From: Matthew Woodward
Sent: 07 February 2017 11:37
To: 'Nick Willock'
Subject: FW: Planning Application - 2017/90207

From: Matthew Woodward
Sent: 02 February 2017 09:25
To: 'nick@roberthalstead.co.uk'
Subject: Planning Application - 2017/90207

Outline application for erection of B1 light industry

Thongsbridge Mills, Miry Lane, Thongsbridge, Holmfirth, HD9 7RW

PROPOSED ACCESS FROM BOTH DIRECTIONS
SCALE: 1:250

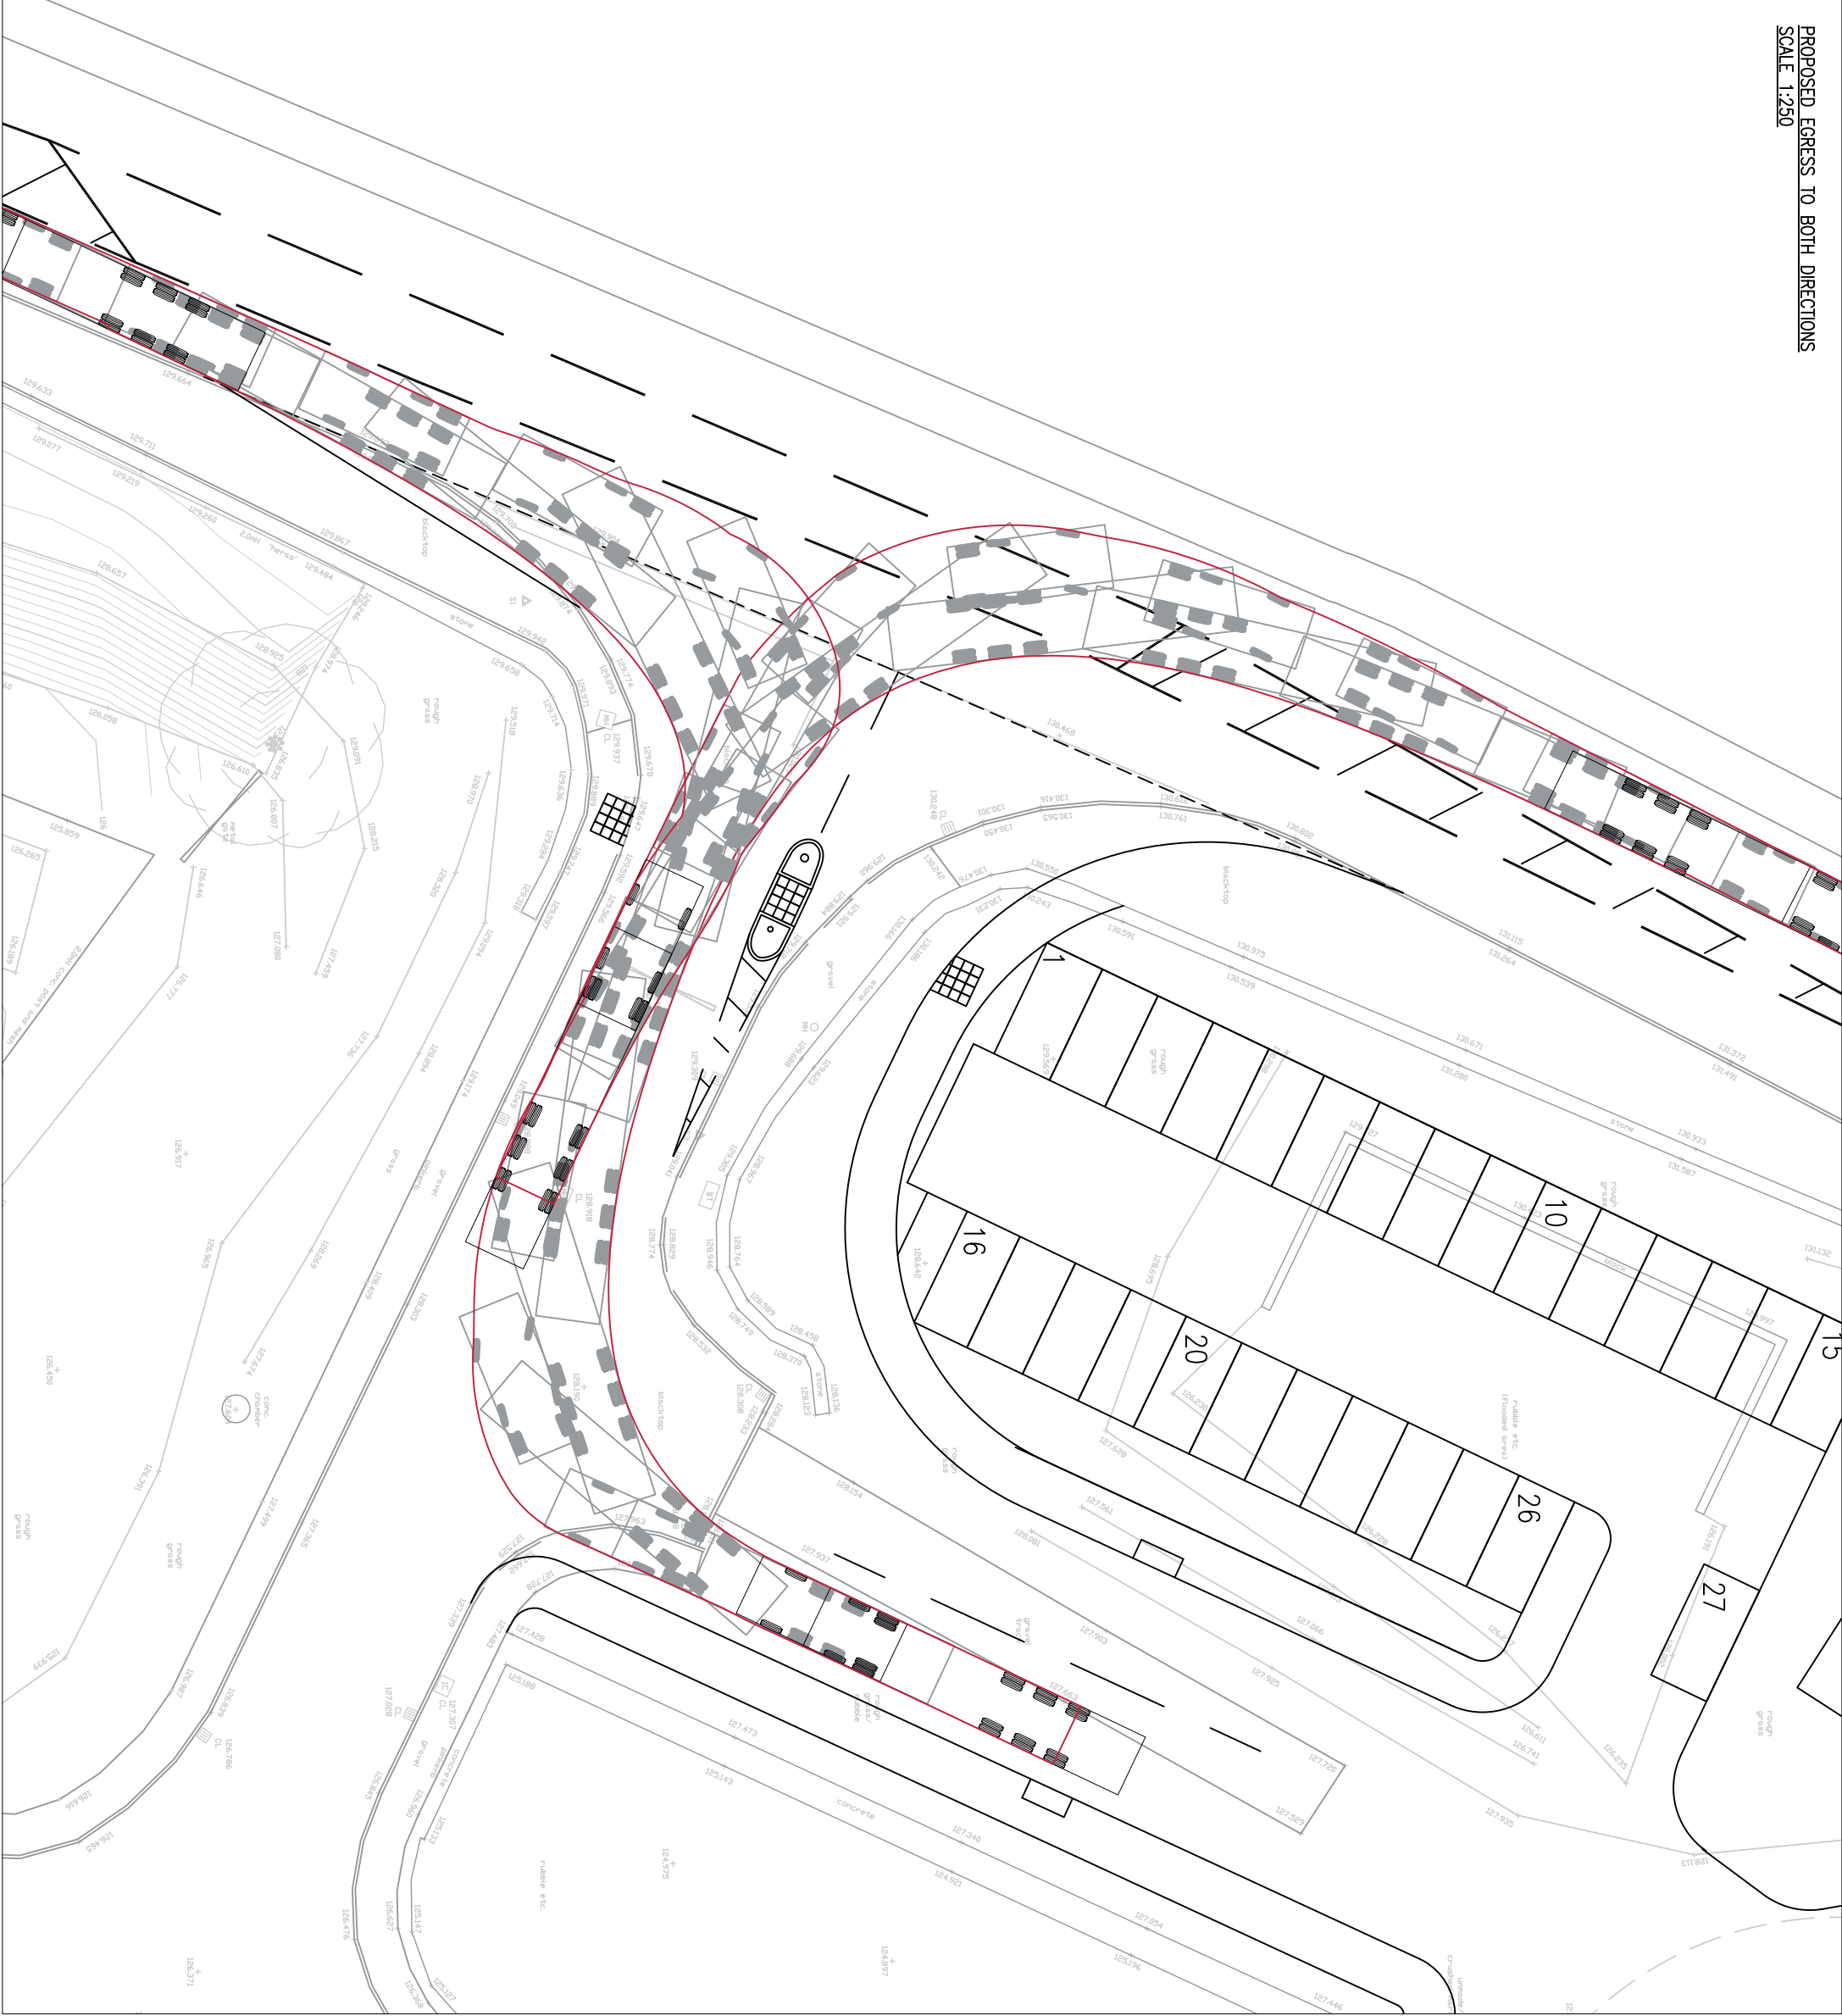
- 1) I cannot locate any access details other than an indicative access location, even though you are applying for full access details. Full plans showing details of the proposed access will be required even if the access is to remain unchanged.
- 2) I would expect the submission to include an indicative layout in order that the Council can understand how a building on the scale you propose will 'fit' in with its surroundings.
- 3) Scale parameters. No details submitted. I require an indication of the upper and lower limits for height, width and length of the building within the site boundary.
